Planning Application Ref: P/75/19/T

Location: 8 Manor Park, Nyetimber, PO21 3JS

Description of works: Fell 1no. Monterey pine (T1). Deadwood and remove cones to 3no. Monterey pine

PLAN 1

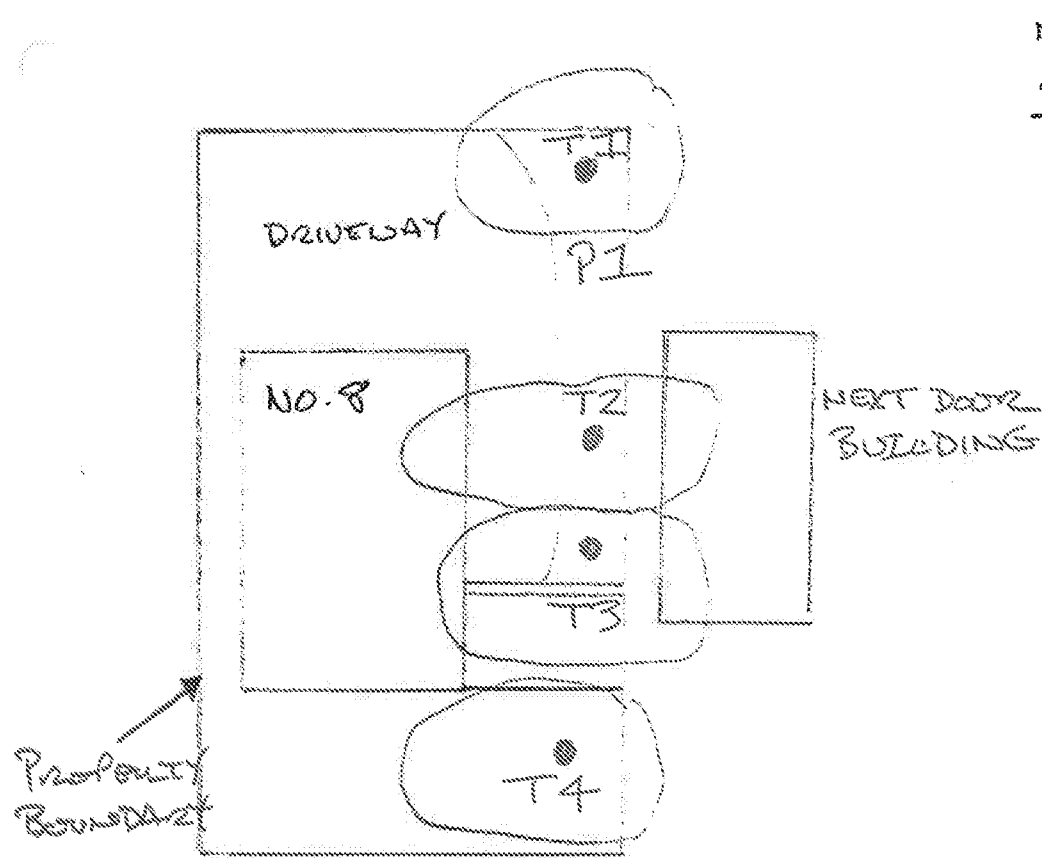
- The applicant has employed the Goodwood Estate as agent, to prepare and submit a tree survey and plan. This is comprehensive and includes a detailed work specification with satisfactory reasons given for each item.
- T1 possesses a high percentage of dead branches and displays low crown density. It is highly probable the tree is in terminal decline.
- T2-T4 inclusive appear to be outwardly healthy and stable at this time. They dominant the property and large limbs/branches overhang the dwelling.
- They are large trees individually and collectively represent a significant local landscape feature, visible from numerous surrounding properties and to users of public highway (footway and carriageway).
- The removal of dead branches is an exception and does not require permission from the local planning authority.

- T1 – The work proposed is necessary to remove an unacceptable level of risk of harm to persons or property.
- T2-T4 incl. - The work proposed for is justified on arboricultural grounds as it seeks to abate a nuisance and without causing undue harm to the trees.

- Once the tree (T1) has been felled (and either grubbed or ground out) then a replacement tree is to be planted in the same place or nearby and to within 4metres.

This is to be of Standard Nursery Stock proportions (10-12cm girth & 2m to 3m overall height) supported on a 'short stake' system with appropriate securing ties and pads.

It is to be planted within 12 months of the removal of the pine tree.

The species shall be selected from the following:-

Field maple *Acer campestre*

Pedunculate oak *Quercus robur*

Wild cherry *Prunus avium*
